DEVELOPMENT REVIEW BOARD
SUPPLEMENTAL SUBMITTAL

PROJECT NO. PR-2021-006571
Application No. SD-2022-00073

Re: Final Plat Review for Proposed Subdivision of Lots 58 and 59 of Rossiter Addition

Plat for Lot 58-A
Rossiter Addition
Being Comprised of
Lots 58 and 59
Rossiter Addition
City of Albuquerque
Bernalillo County, New Mexico
April 2021

DOCH 2022105183
12/09/2022 09:58 AM Page: 2 of 2
PLAT R 326 00 B: 2022C P: 0138 Linda Stover, Bernalillo County

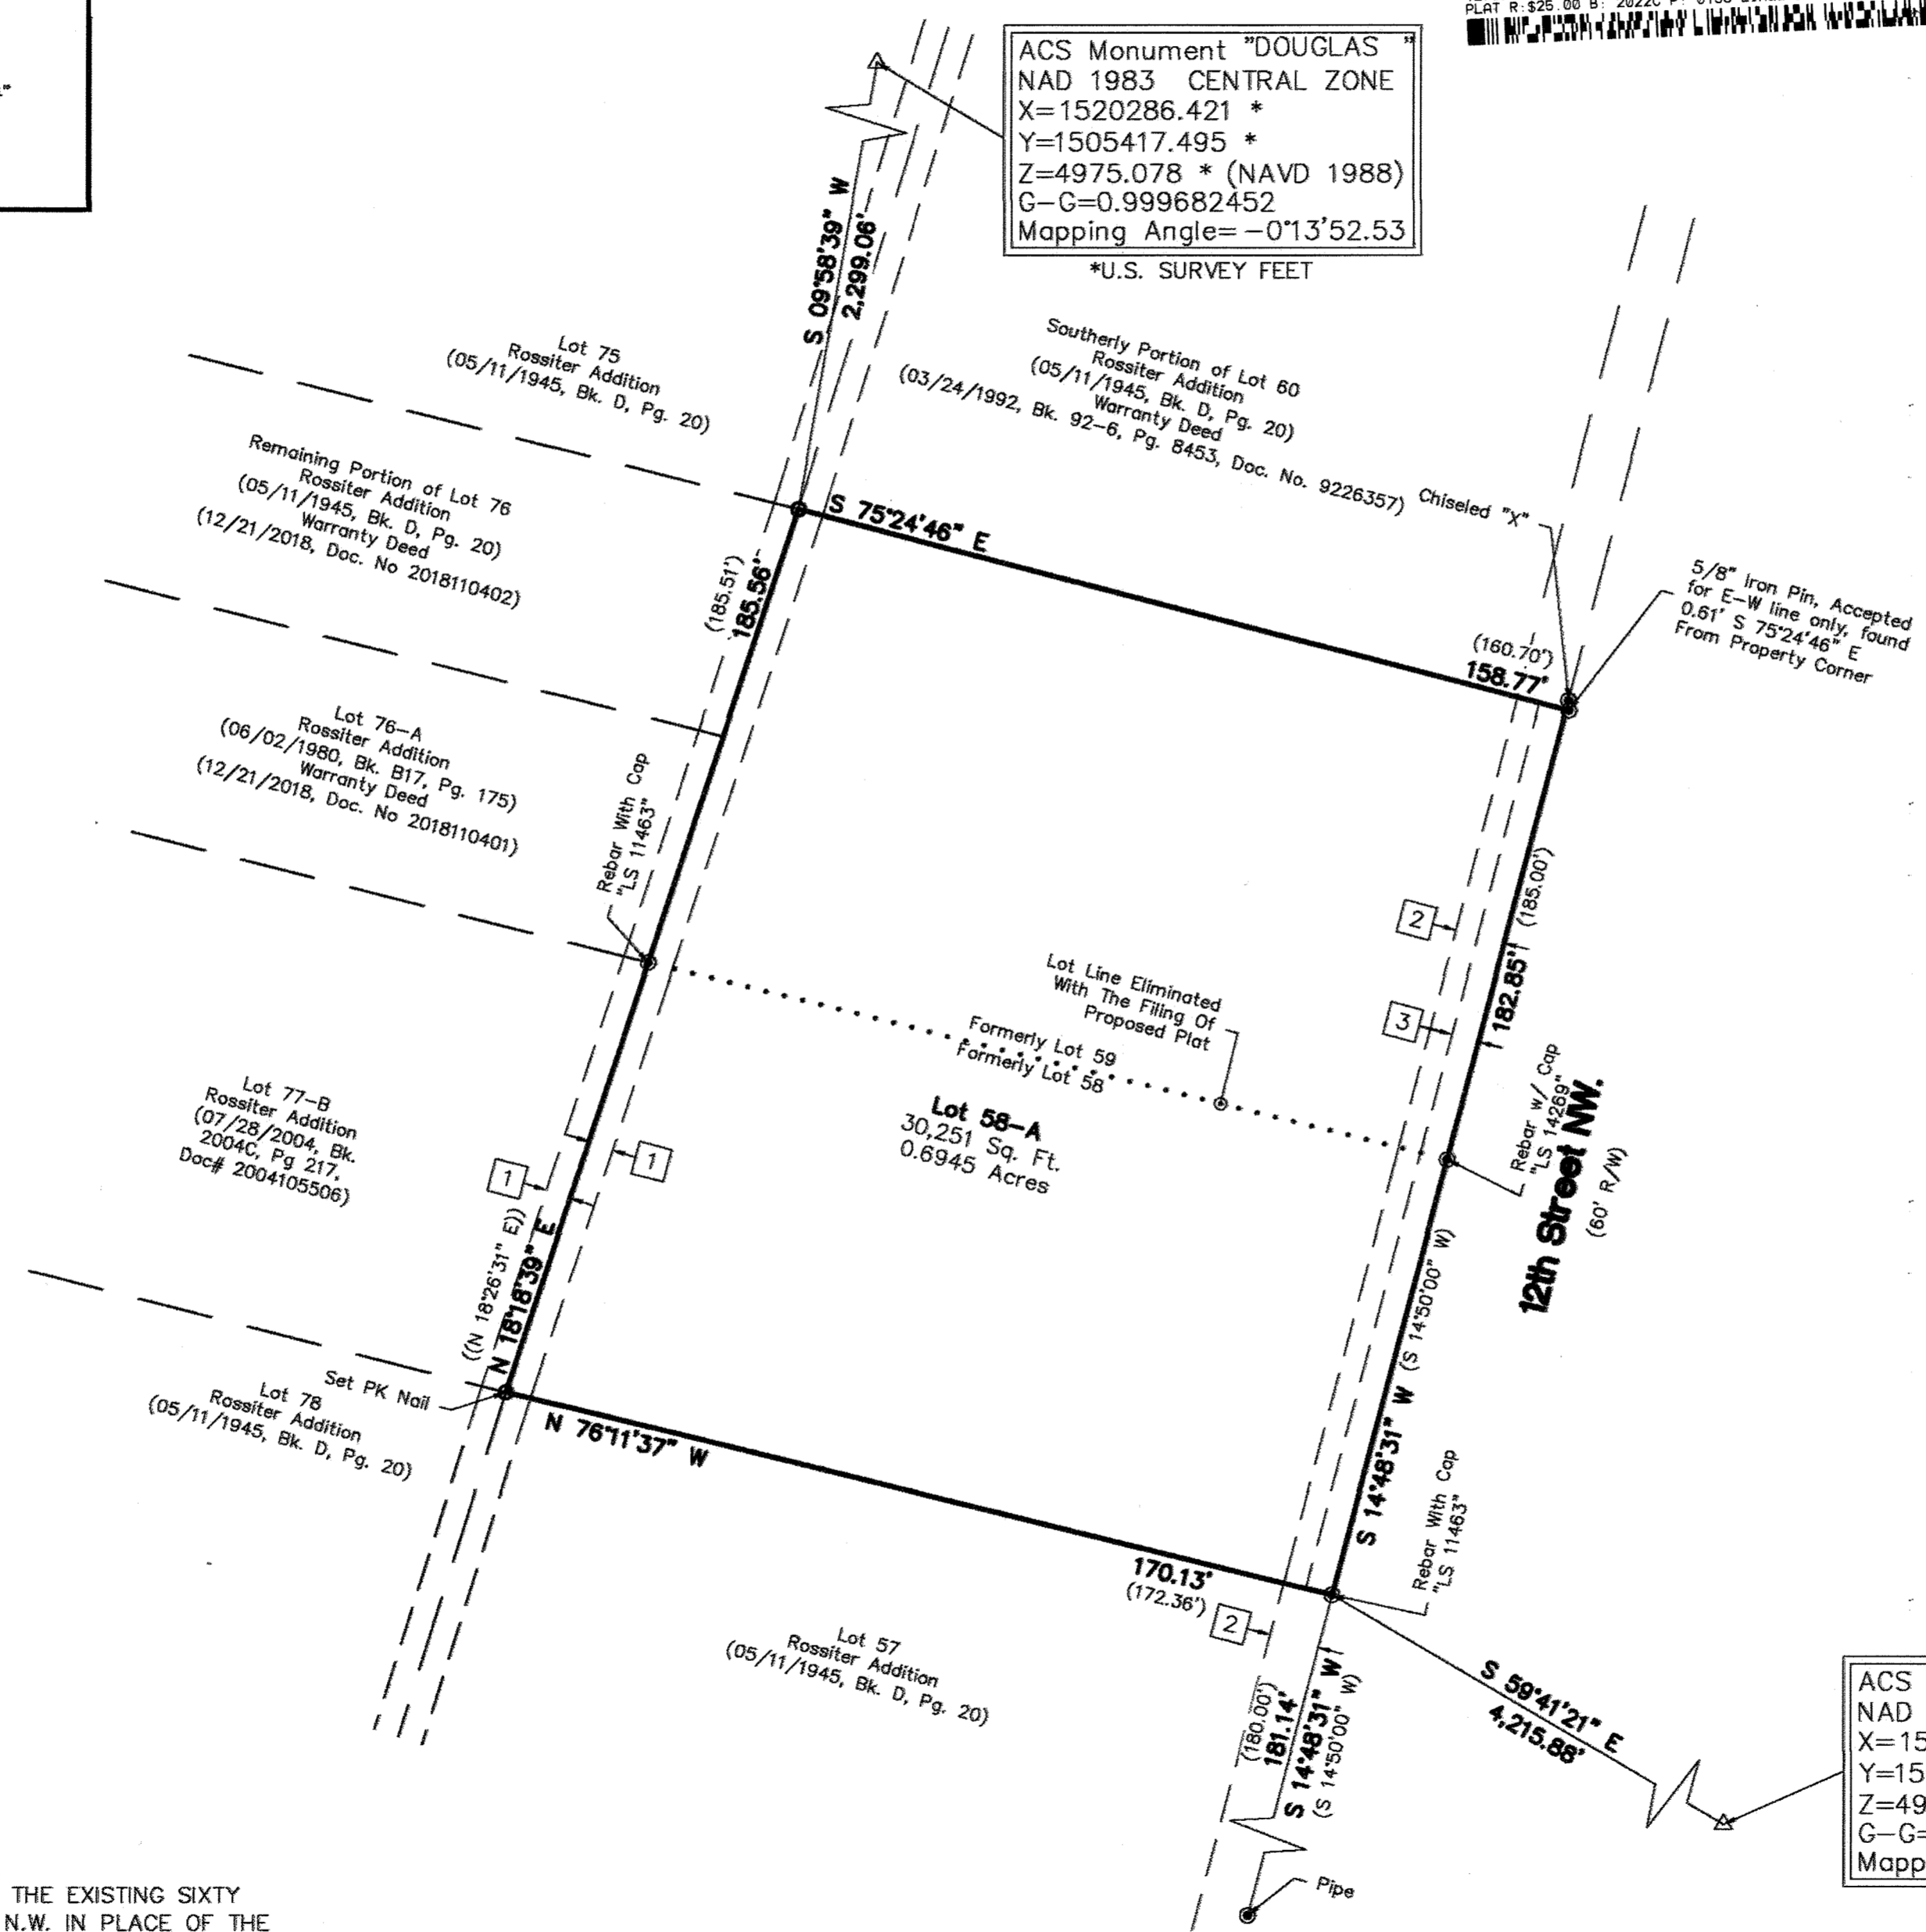
1. The minimum sidewalk required on 12th Street is 6 feet. (This shall be added to an infrastructure list.) Adjust right-of-way width to accommodate this sidewalk. A 4-foot minimum ADA pathway shall be provided around the powerpole.

2. Because 12th Street is a major collector street, the minimum right-of-way width shall be 62 feet wide. This should be accomplished with the new sidewalk requirement.

Noted, a 5.5 foot sidewalk easement is to be granted on the plat which will allow for construction of sidewalk and ADA compliant clearance around the utility pole in the sidewalk.

Noted, a request for an administrative decision allowing the existing right-of-way width is requested on a separate justification letter given the buffer requirements from the adjoining residential development and the granting of a sidewalk easement to accommodate sidewalk widening.
